CITY OF ALBUQUERQUE
PLANNING DEPARTMENT
DEVELOPMENT REVIEW BOARD

Project# 1009046

12DRB-70115 MAJOR - PRELIMINARY PLAT APPROVAL

MARK GOODWIN AND ASSOCIATES, P.A. agent(s) for SAWMILL CROSSINGS, LLC request(s) the referenced/ above action(s) for Tract B1A2, **DUKE CITY LUMBER CO ADDITION**, zoned SU-2/S-I (proposed SU-2/ SU-1 PRD), located on the south side of ASPEN AVE NW between 12TH ST NW and 19th ST NW containing approximately 6.9292 acre(s). (H-13)[*Deferred from 5/2/12, 5/23/12, 6/6/12*]

PRELIMINARY PLAT FOR  
**SAWMILL CROSSING**  
**UNIT 1**  
WITHIN THE  
TOWN OF ALBUQUERQUE GRANT  
PROJECTED SECTION 7  
TOWNSHIP 10 NORTH, RANGE 3 EAST, N.M.P.M.  
CITY OF ALBUQUERQUE BERNALILLO COUNTY, NEW MEXICO  
MARCH, 2012

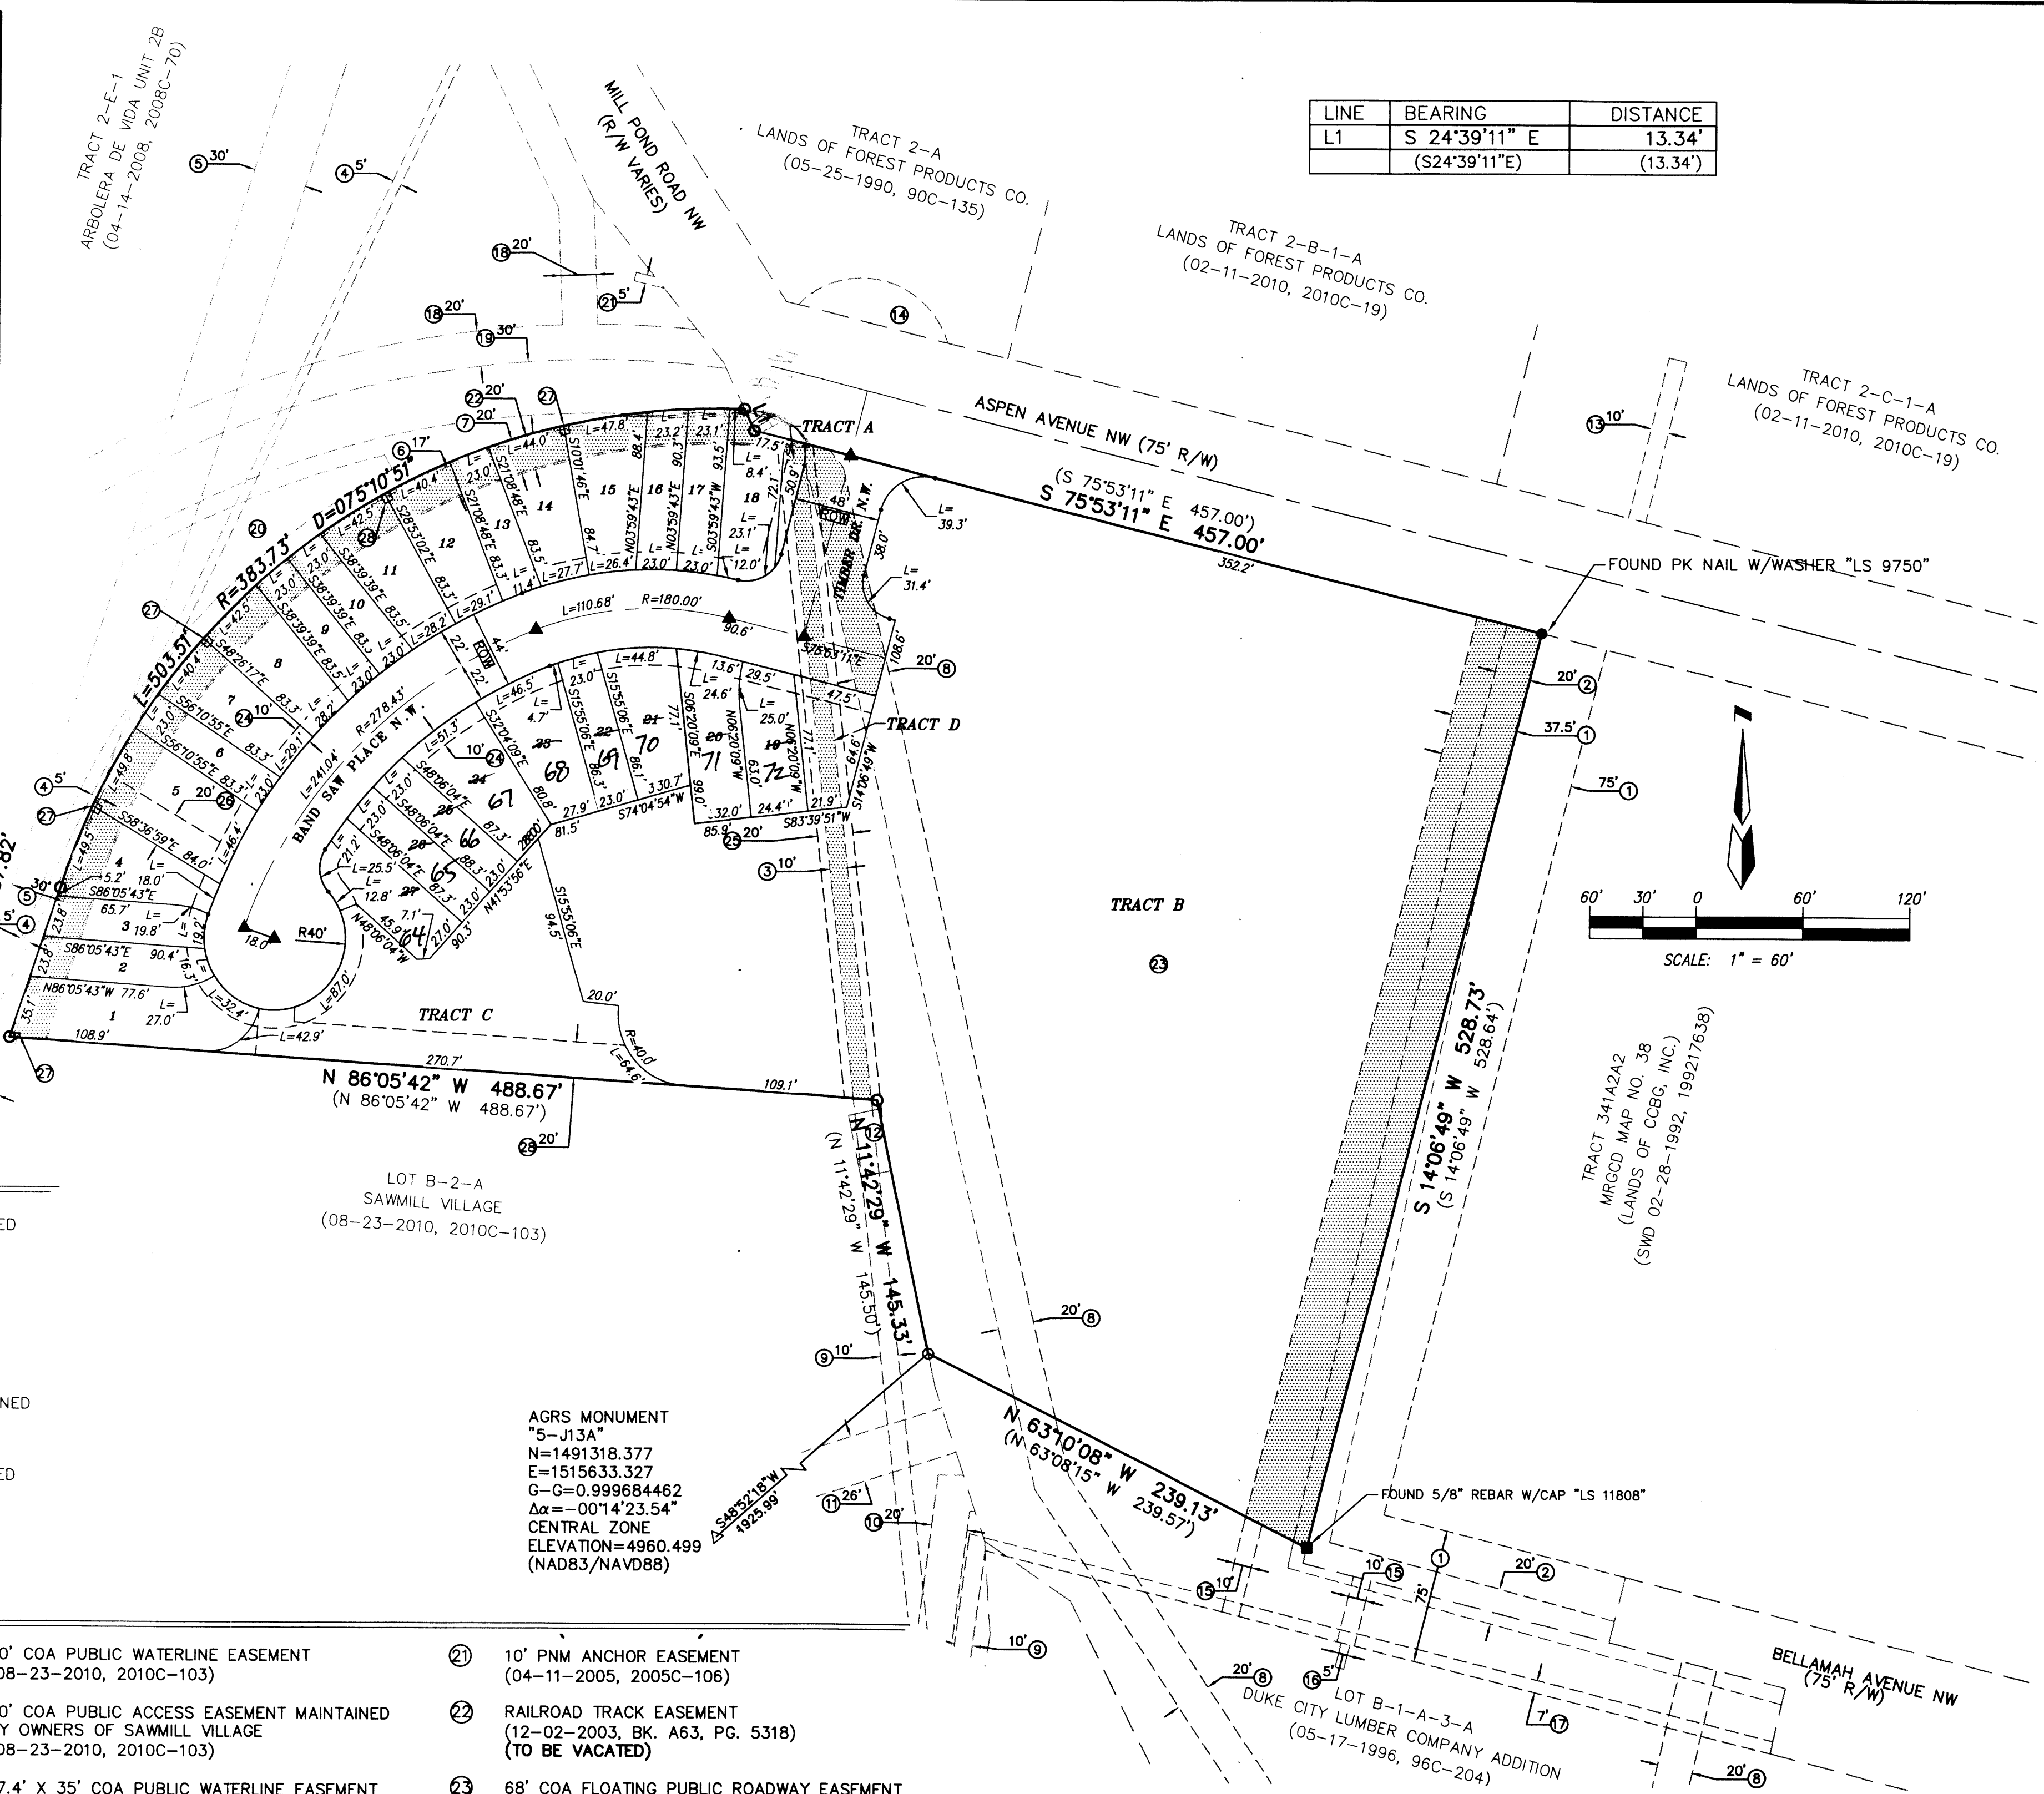
- The Tri-Party Agreement between the developer, the City of Albuquerque, and the NMDOT is required prior to Final Plat.
- The railway crossing must be approved prior to Final Plat.
- Note 9: Show the 3 foot easement on Tract B and it will also be required to be shown on Tract C on the Final Plat.
- Note 10: The sidewalk culverts should be maintained by the property owner on the lot where the sidewalk culvert is built. Change the note by ending the sentence after the word "...owner" on the Final Plat
- A recorded SIA is required prior to applying for Final Plat.
